BIG O TIRES
6985 N. MERIDIAN RD.
PEYTON, CO 80831
EL PASO COUNTY, COLORADO

LANDSCAPE

PLAN

PPR1836

SHEET NO.
8 OF 11

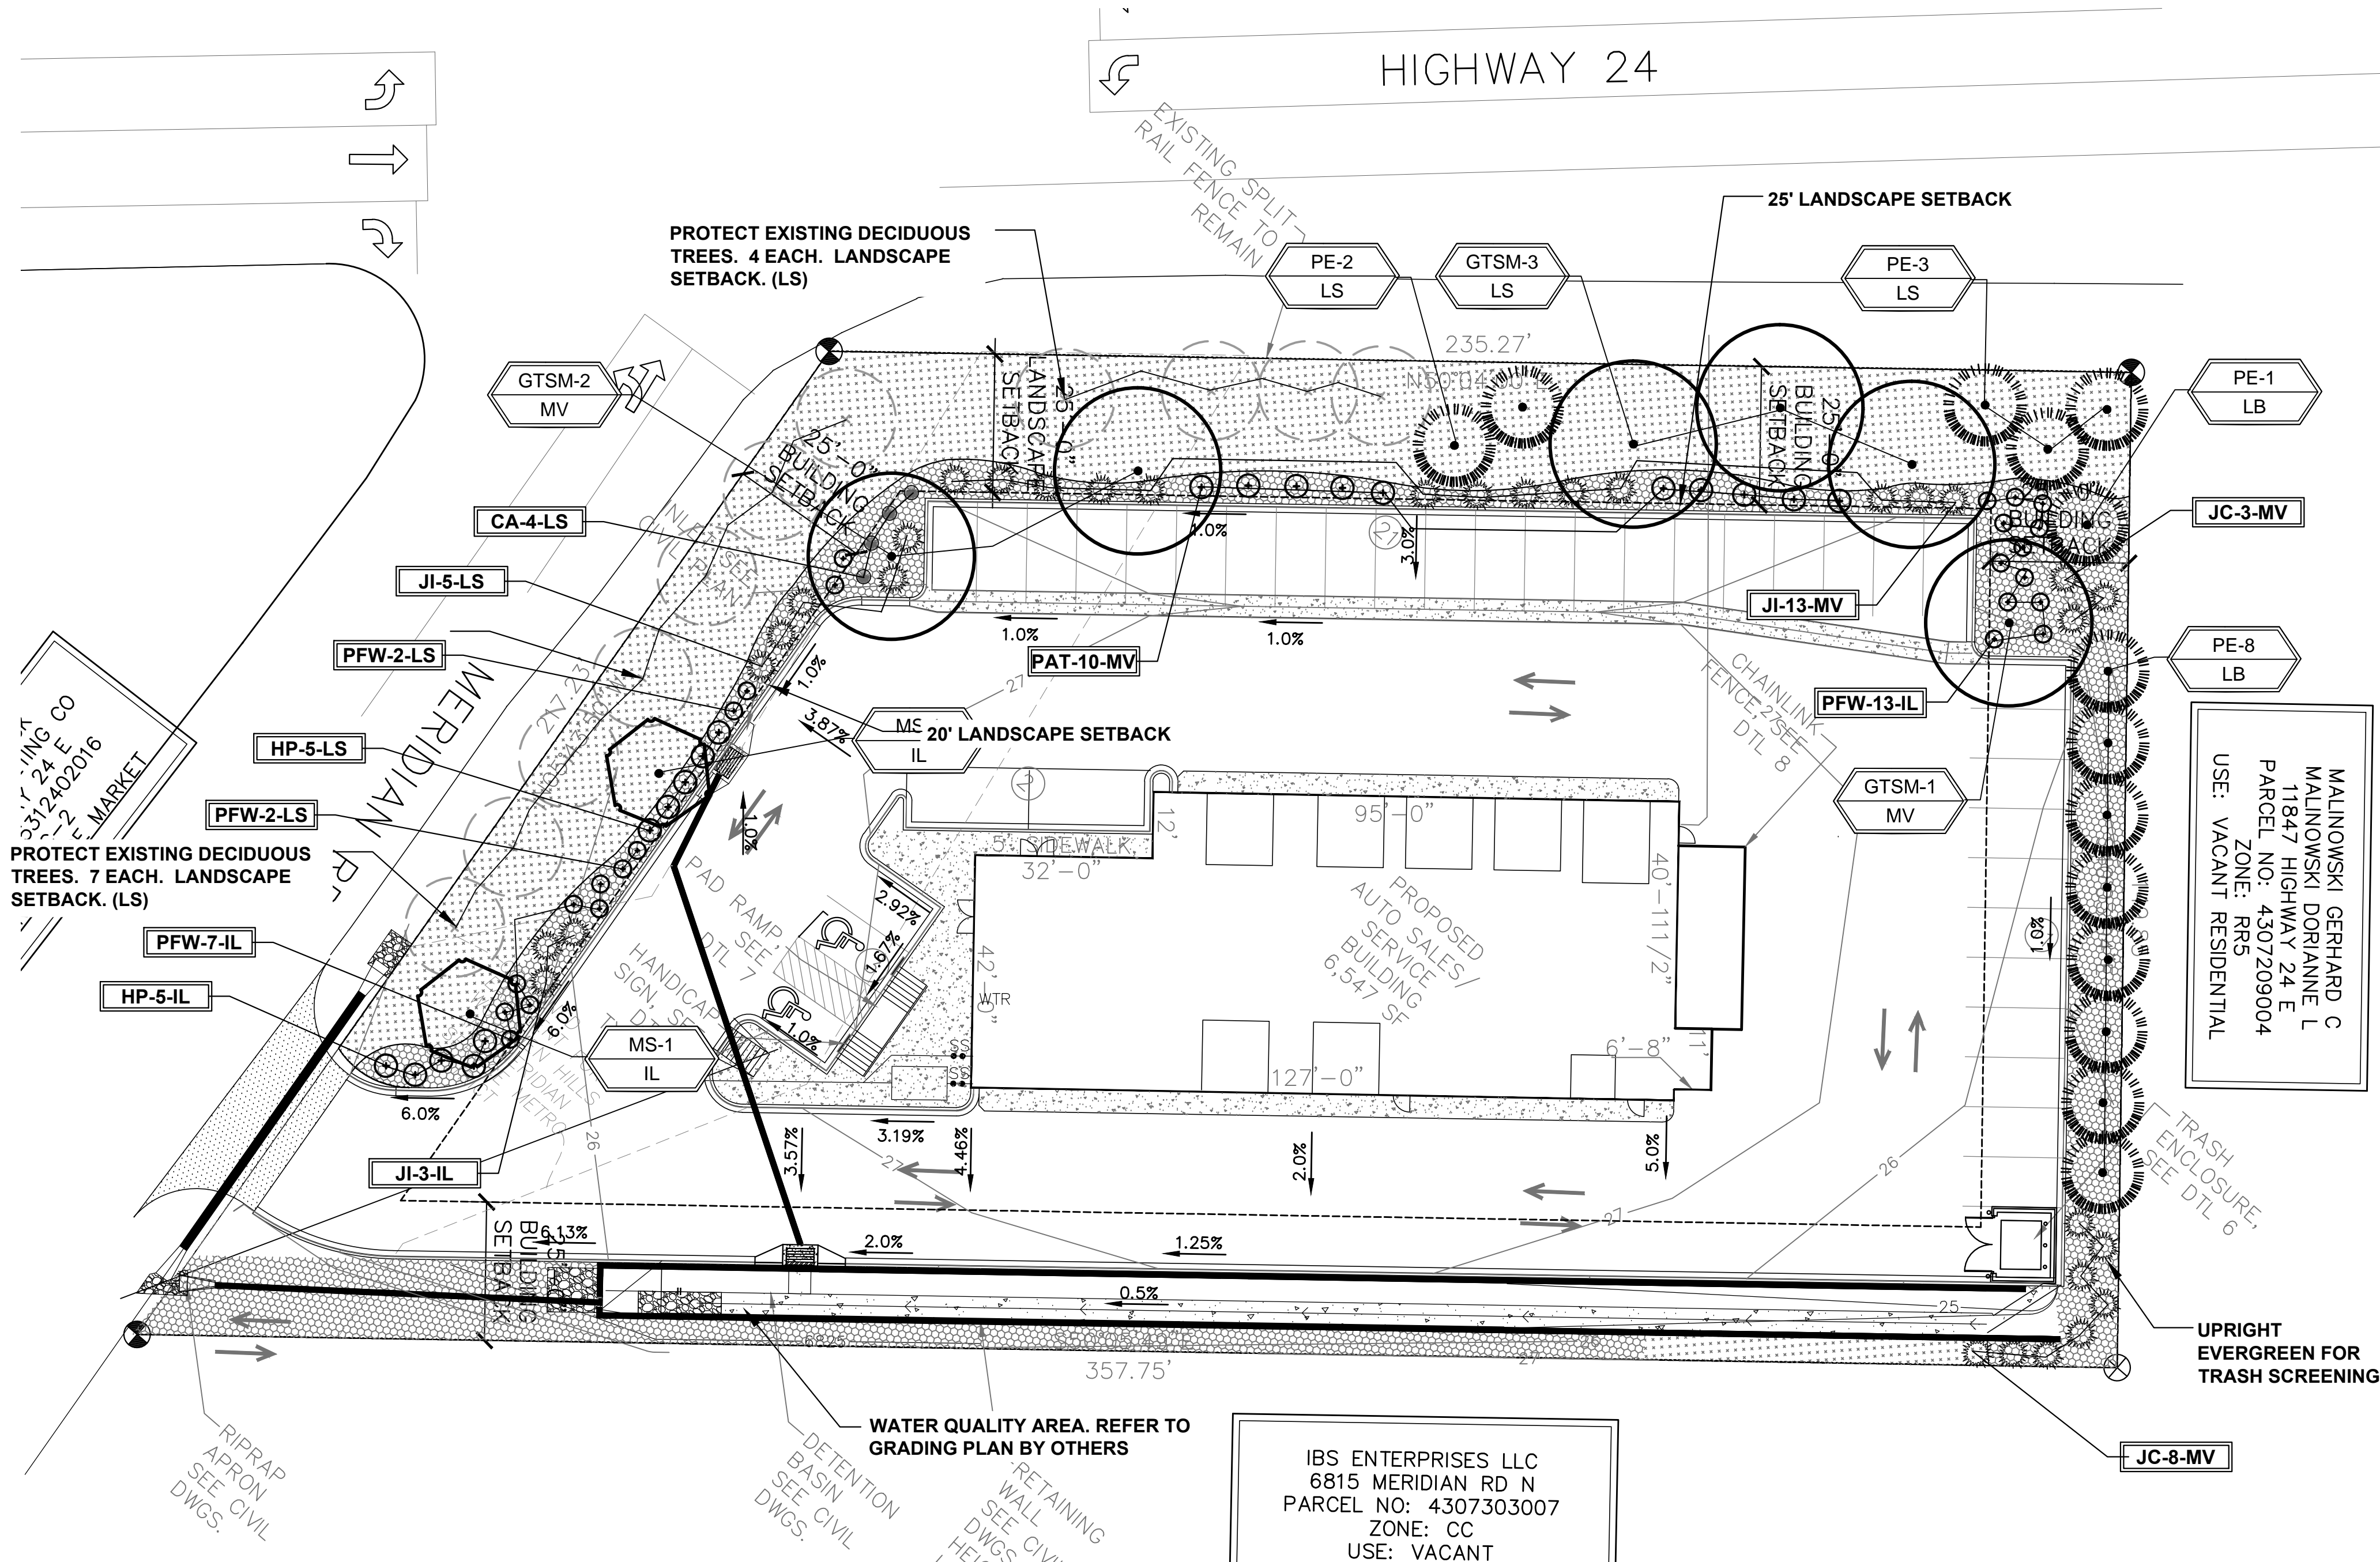
write that the 30 shrubs are substituted here

write that the 30 shrubs are substituted here
